Application No: EP/93/20/HH  
Site Address: 7 North Lane East Preston BN16 1BN  
Description of works: Erection of a outbuilding for use as a garden store.

Thank you for your internet representation made on 25th September 2020 which has been recorded as an objection with the comments as follows:

Client:
Mr M. Gladish, 7 North Lane, East Preston, BN16 1BN
Project:
Front Garden Store
Drawing Title:
Floor Plan & Elevations

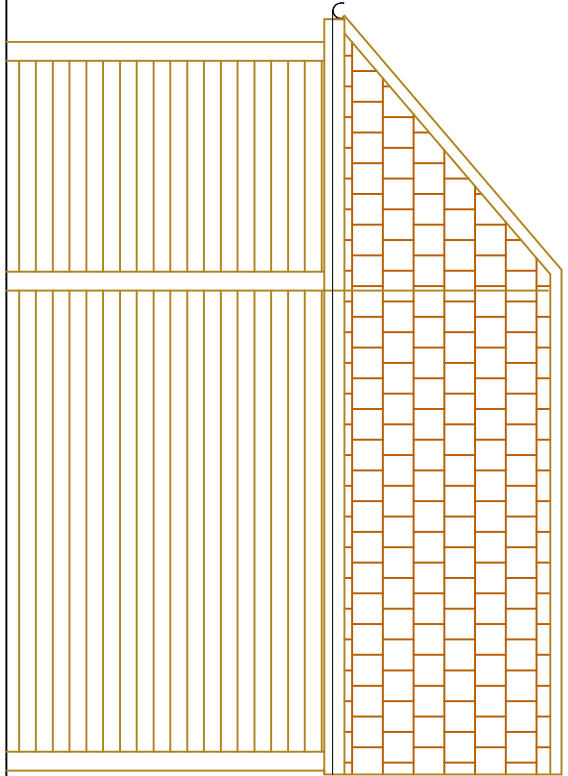
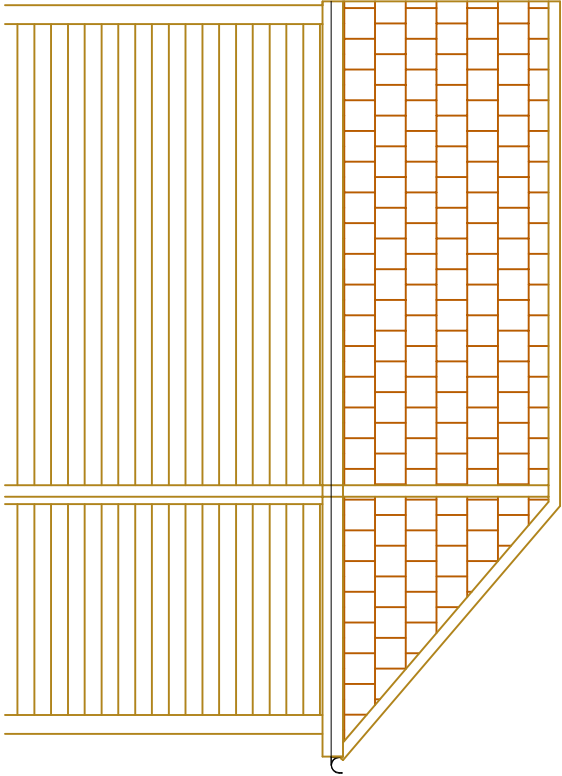
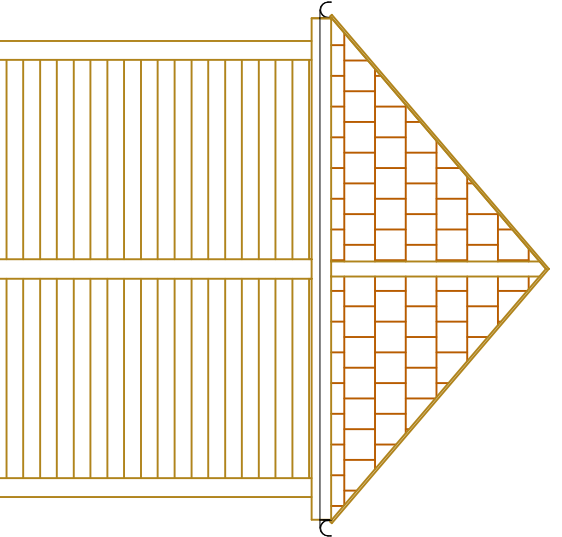
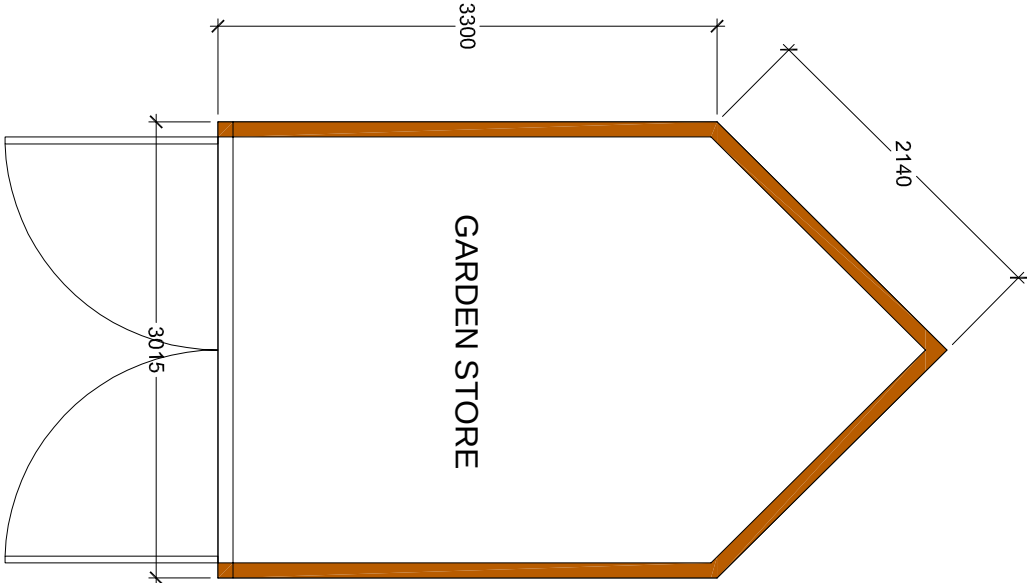
The (proposed) building has had a harmful impact upon the character of the street scene, and the wider locality, due to its appearance and significant scale as a result of its siting. The applicant's own photographs show how prominent this building is, the whole of the roof design visible above the top of the fence.

Drawing Title:
Site Plan

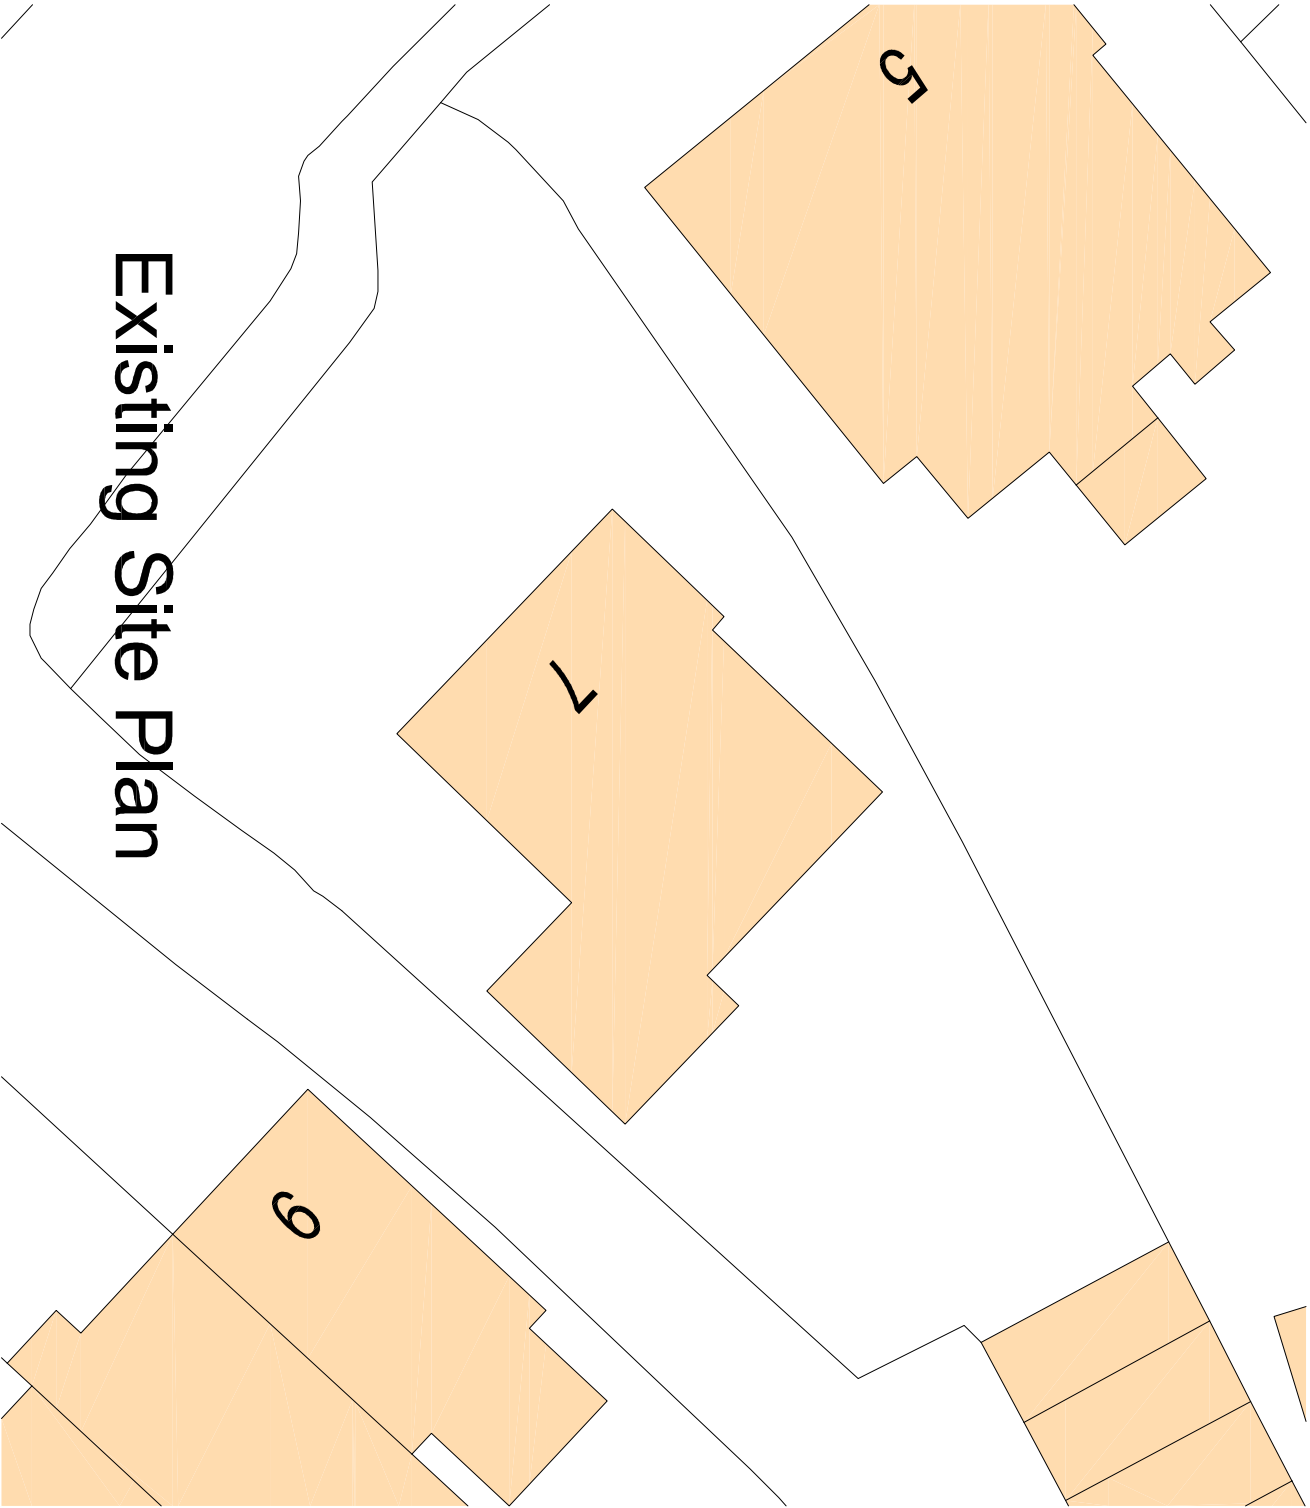
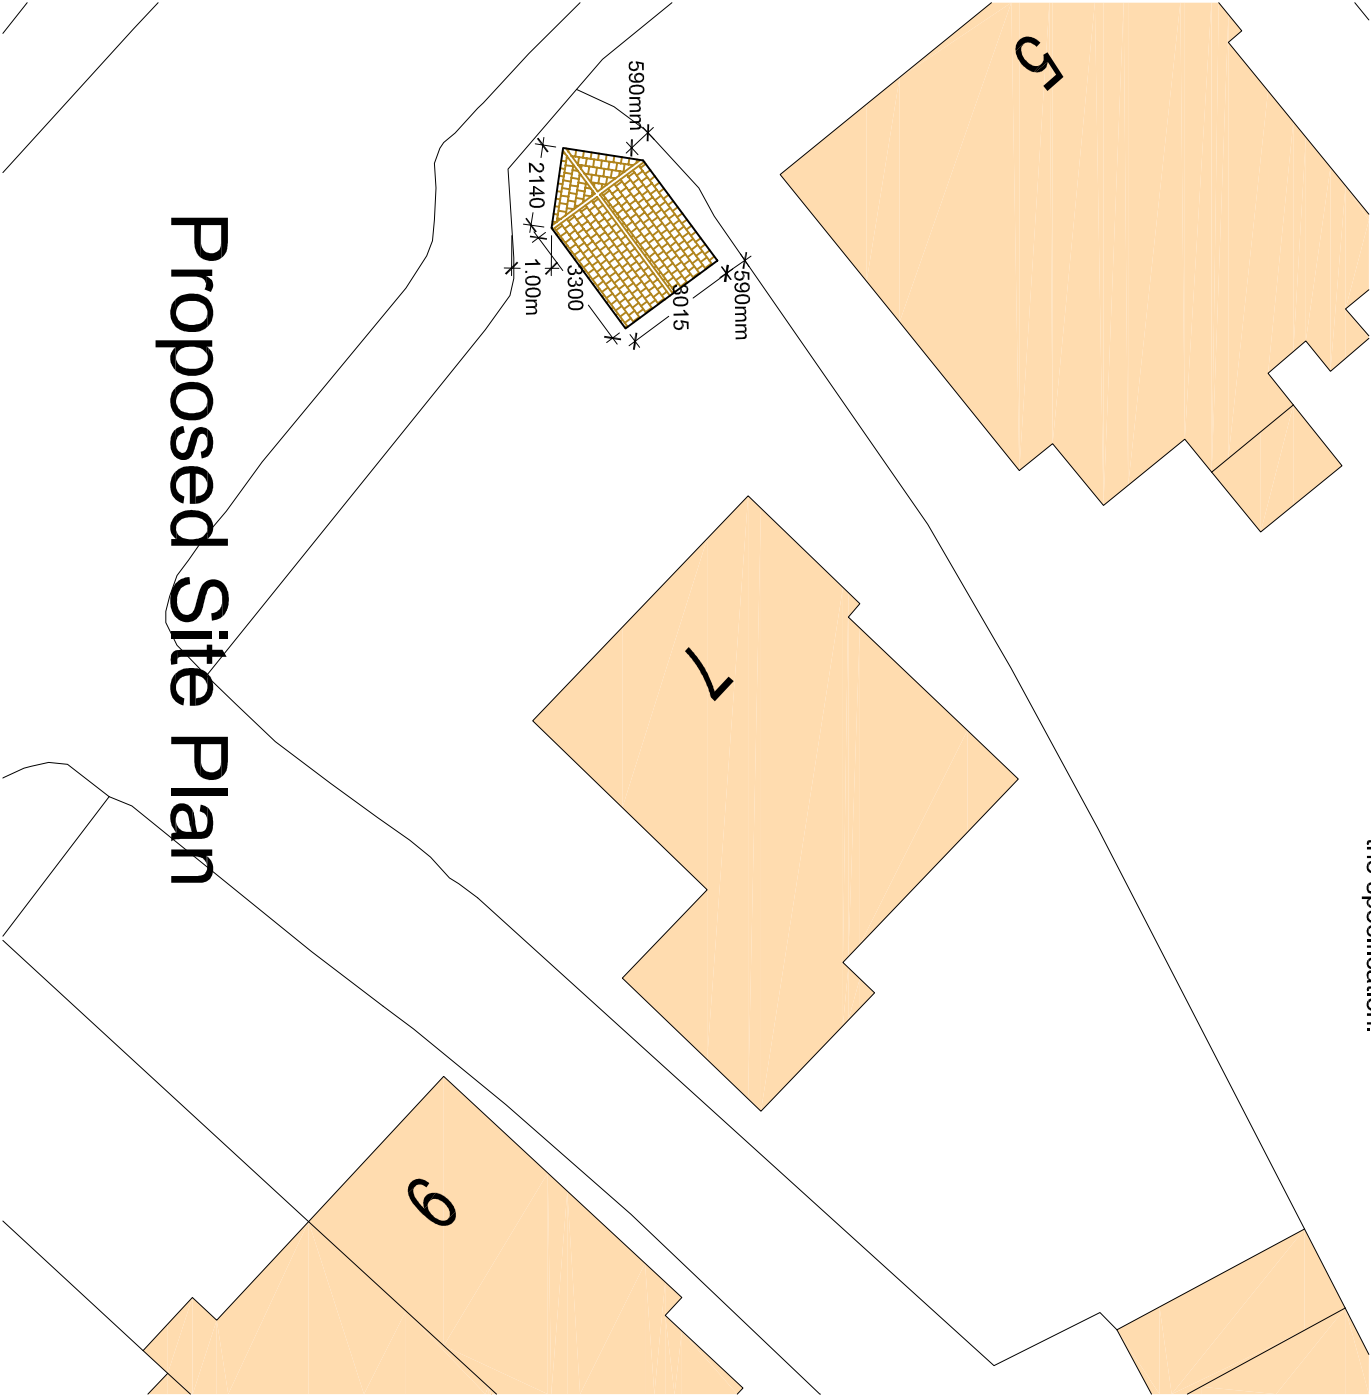
The (proposed) building is also well in front of the building line of all adjacent properties. Again the applicant's own photographs show this.

Contrary to the applicant's assertion in Section 10 of his application form, this council does not believe a suitable boundary distance was maintained. This council questions whether the officer named in the Application should have directed the Applicant to a Planning Officer.
